2024/0545

Address: 18 Clarkes Croft, Wombwell, Barnsley, S73 8BJ

Description: First floor side extension above integral garage to 2 storey semi-detached dwelling

Proposed Elevations.

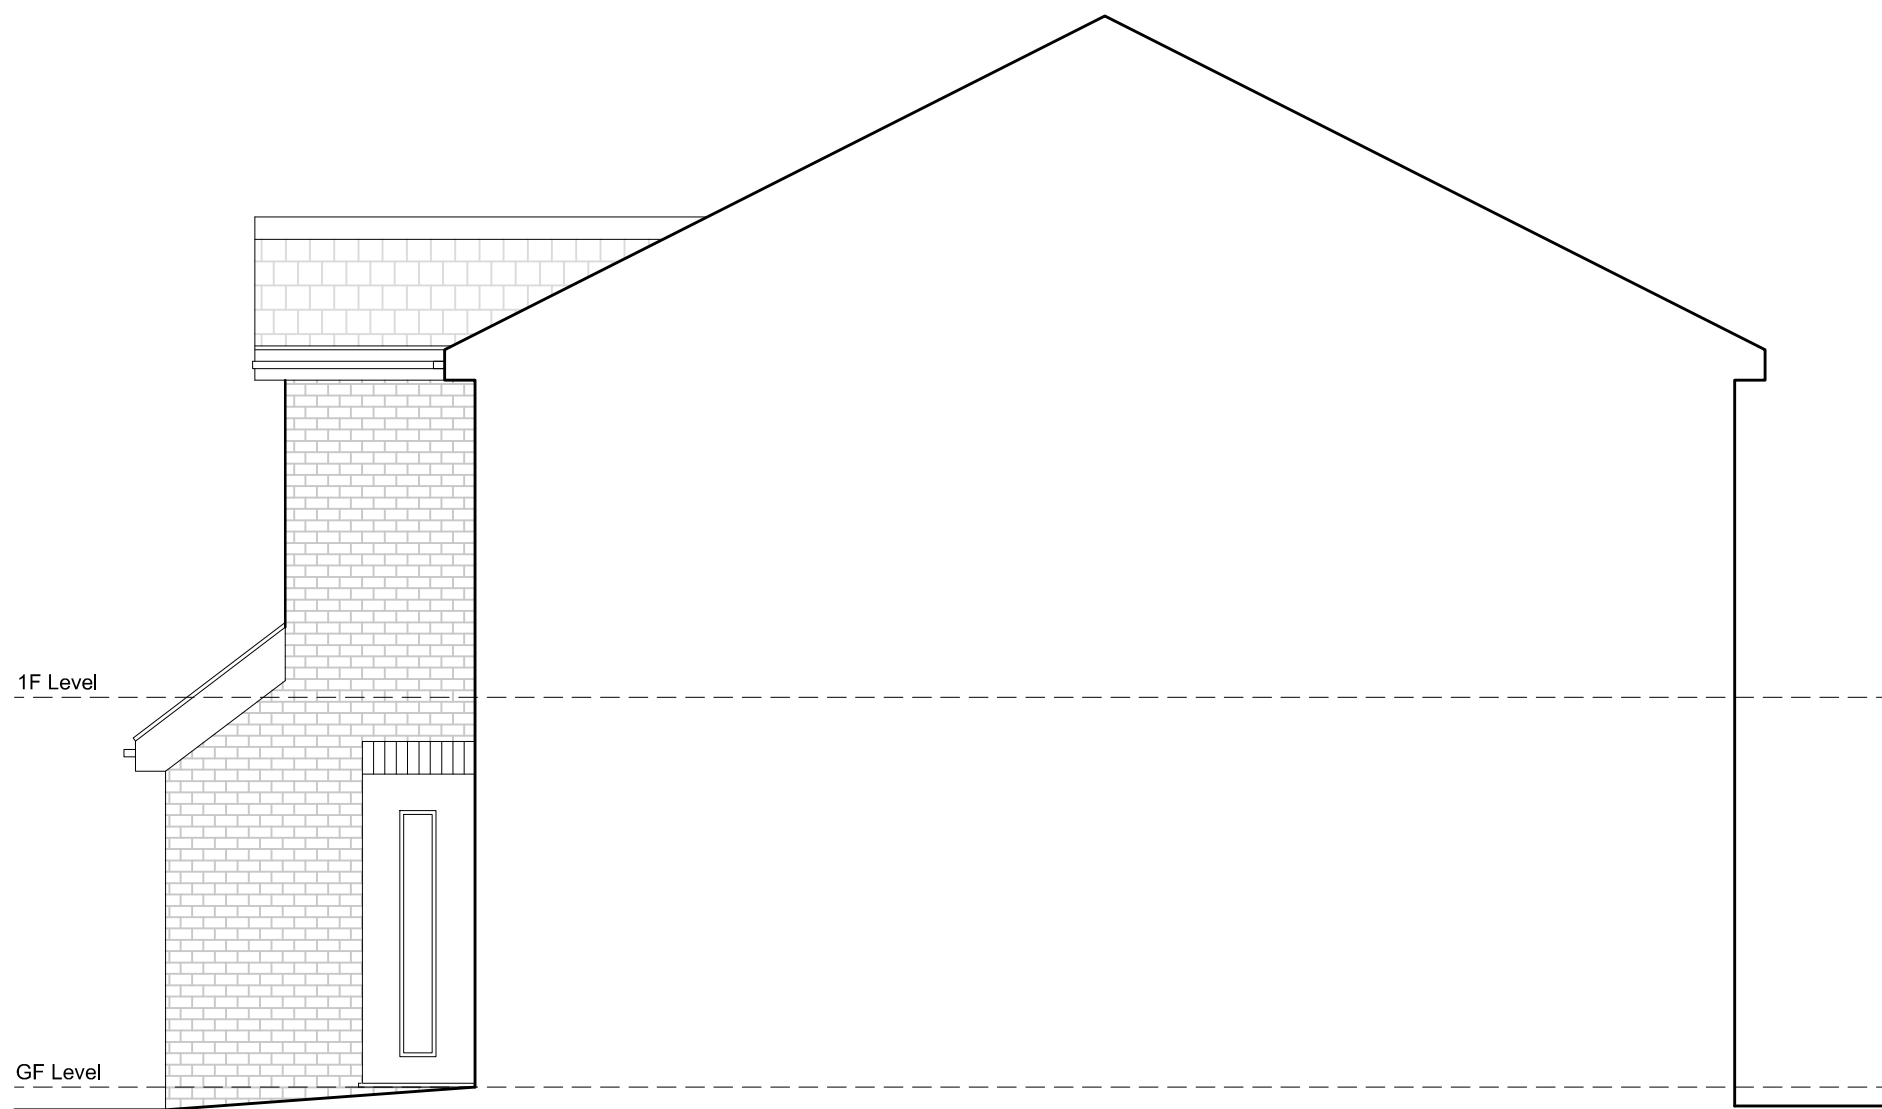
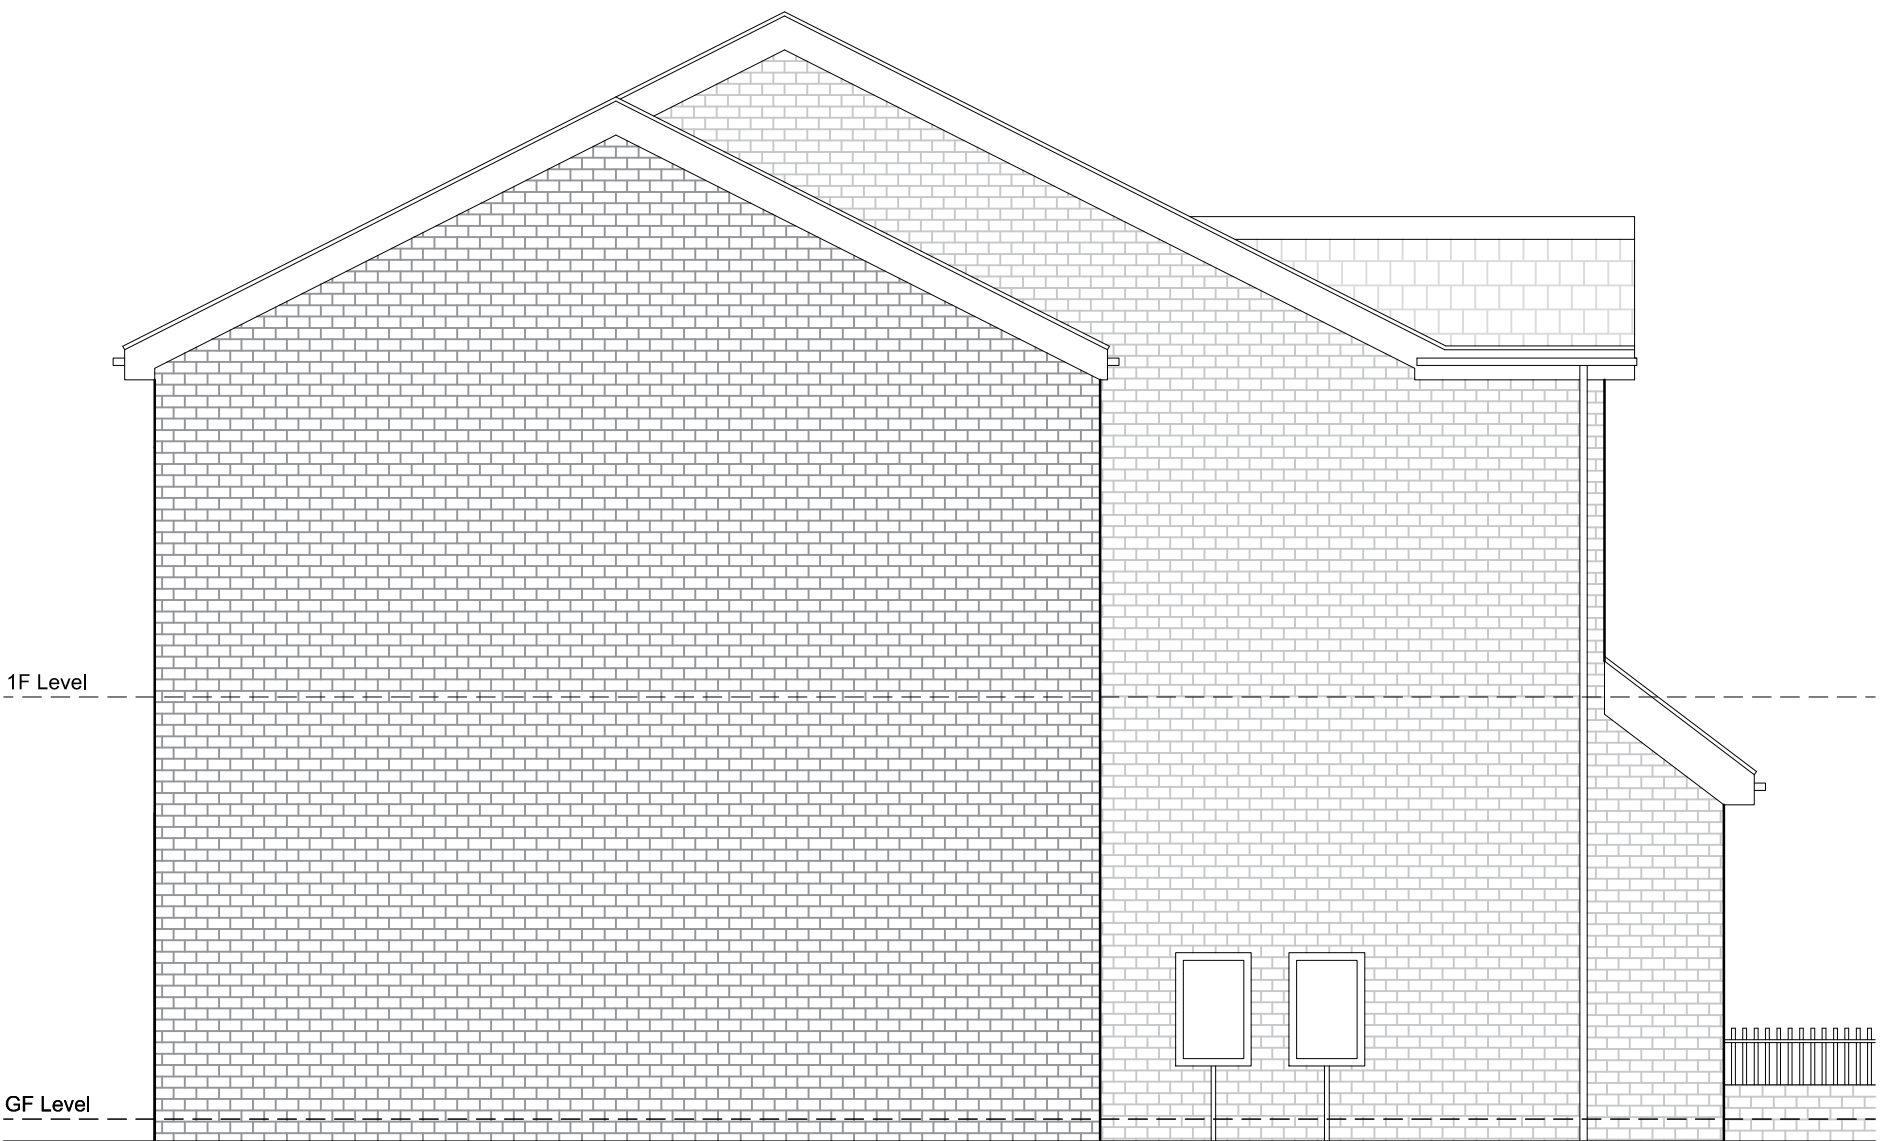
Proposed two-storey garage (existing original garage)

- **Side Projection: 2.9m** (2.9m)
- **Length: 6.25m** (6.25m)
- **Maximum Eaves Height: 5.02m** (2.4m)
- **Maximum roof height: 6.88m** (4m)
-
- **Original House Roof Height: 7.48m**
- **Original House Eaves: 5.02m**

The proposal would have a minor effect upon the neighbouring dwelling of No.20 Clarkes Croft, whilst the proposal includes no side windows, No.20 has two small non-habitable room windows on their side elevation, which may have slightly reduced light levels due to the increased height of the additional story on top of the garage. This impact though would be minimal due to the existing mitigation of the height of the original garage, and positioning of the dwellings. There would be no impact to the neighbouring dwelling of No.16, neither would the proposed window on the front, set back elevation of the first-floor extension have any negative impact on any neighbouring dwelling. The proposed rear window would overlook the side elevation, featuring a door but no windows, of No.24 Marsh Street, to the rear of the dwelling. Whilst the existing master bedroom window would overlook the rear garden of No.24 Marsh Street more than the proposed new rear window, the location of the new window is within the proposed first floor utility room, so would not be considered a habitable room.

The proposal would be slightly out of character with the street scene but would equally not be significantly out of character as too affect the character of the dwelling or the broader street scene, As the existing garage is already set back from the front elevation. The proposed new first floor addition would also be set back. The proposed roof is approximately 0.56m lower than the existing main roof with the eaves height matching the house's eaves height, therefore complying with local guidance of extensions being subordinate to the original dwelling, Matching materials are proposed within the design for both the extension and its roof, complying with policy guidance and minimizing the visual impact of the proposal.

Proposed First Floor Plan
Scale: 1:50

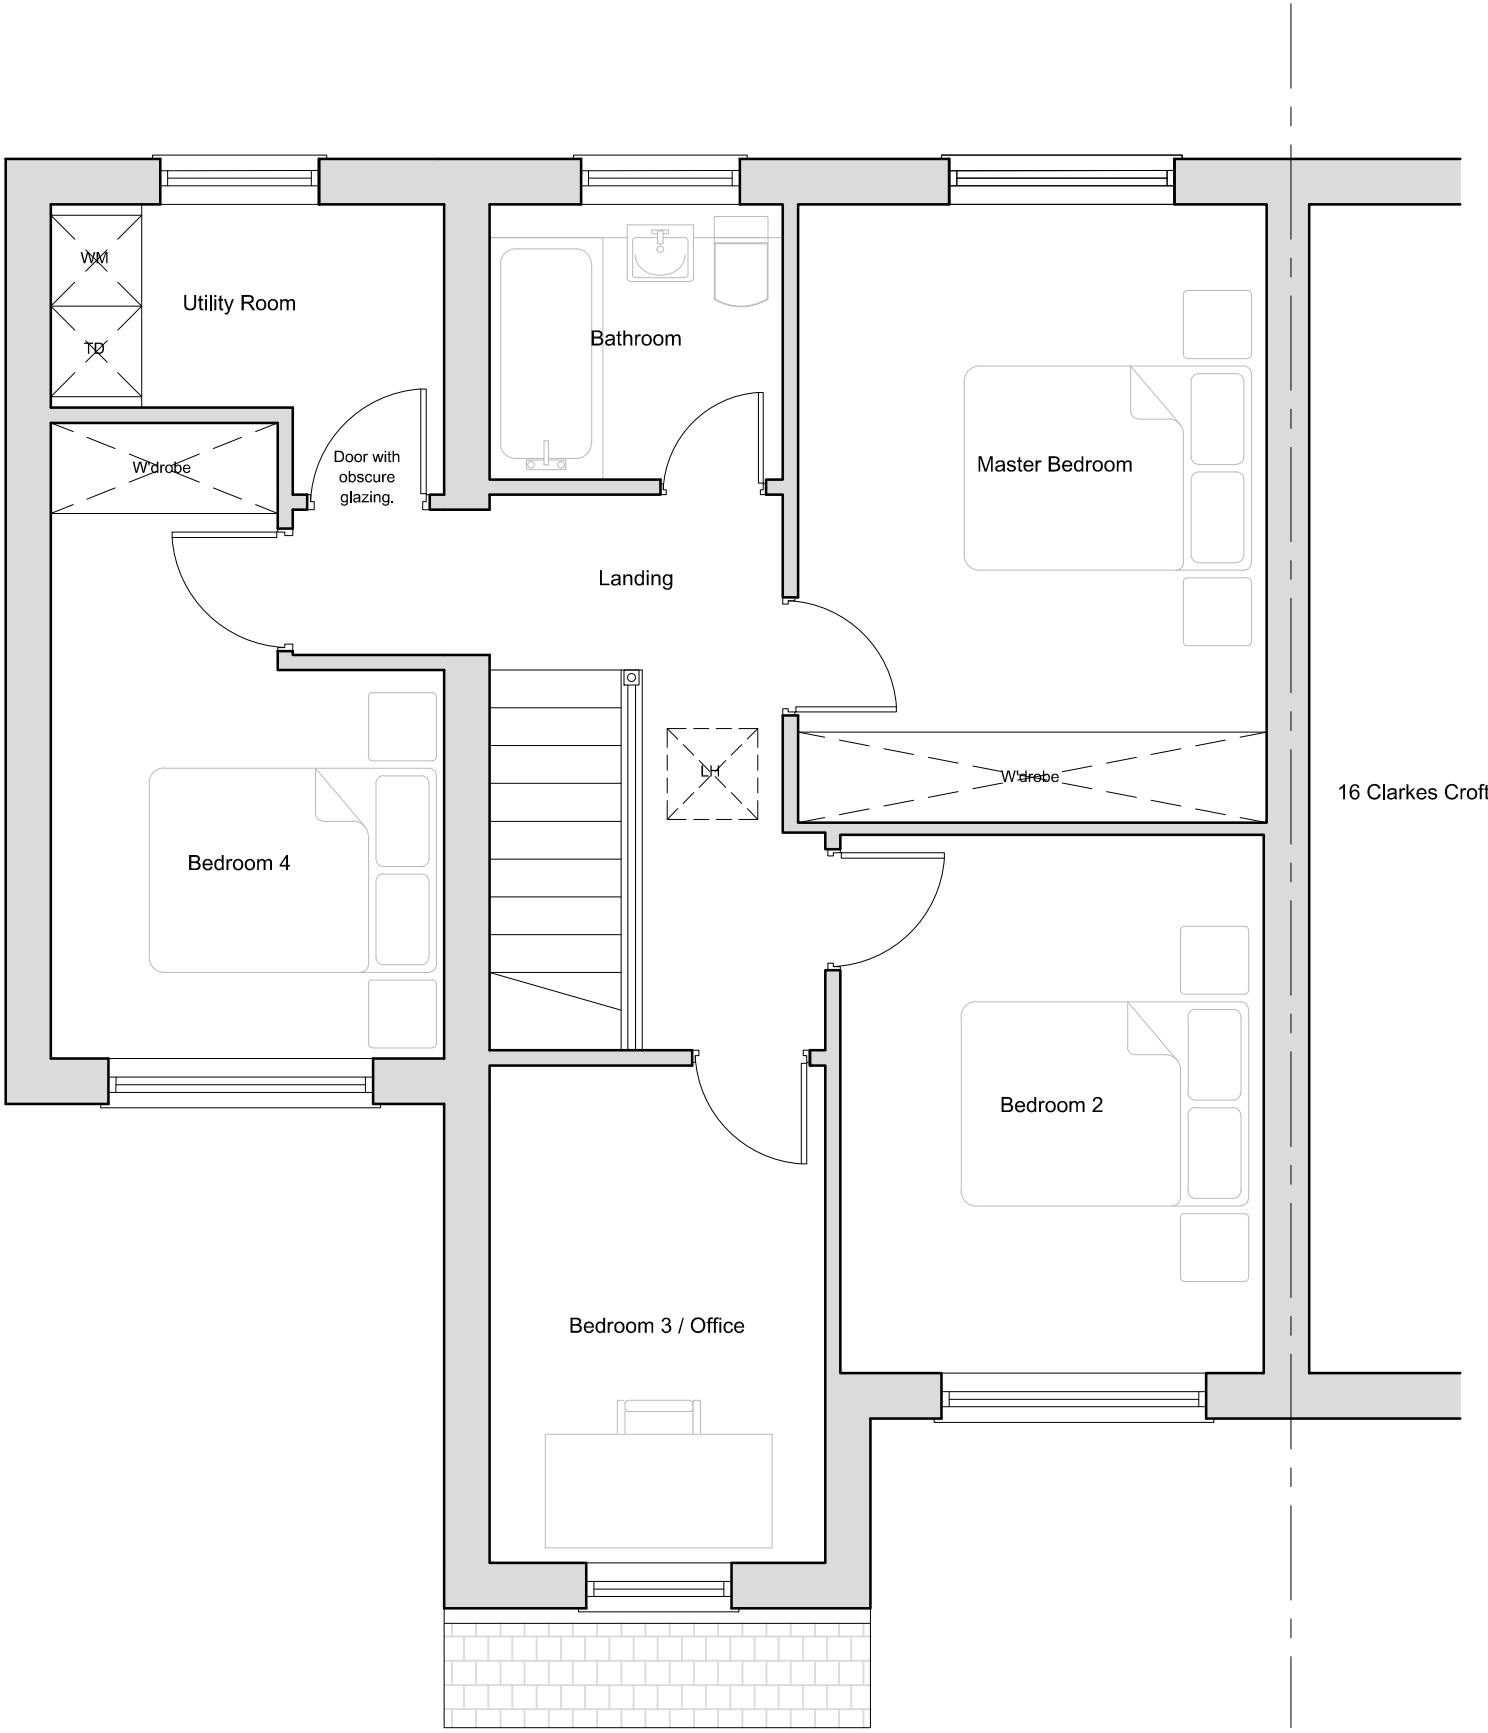
Proposed: The proposal is for a first-floor extension on top of the existing single-story garage. Internally, this would provide an additional bedroom and utility room, with one front and rear window in each room respectively. The ground floor garage is proposed to remain as a garage.
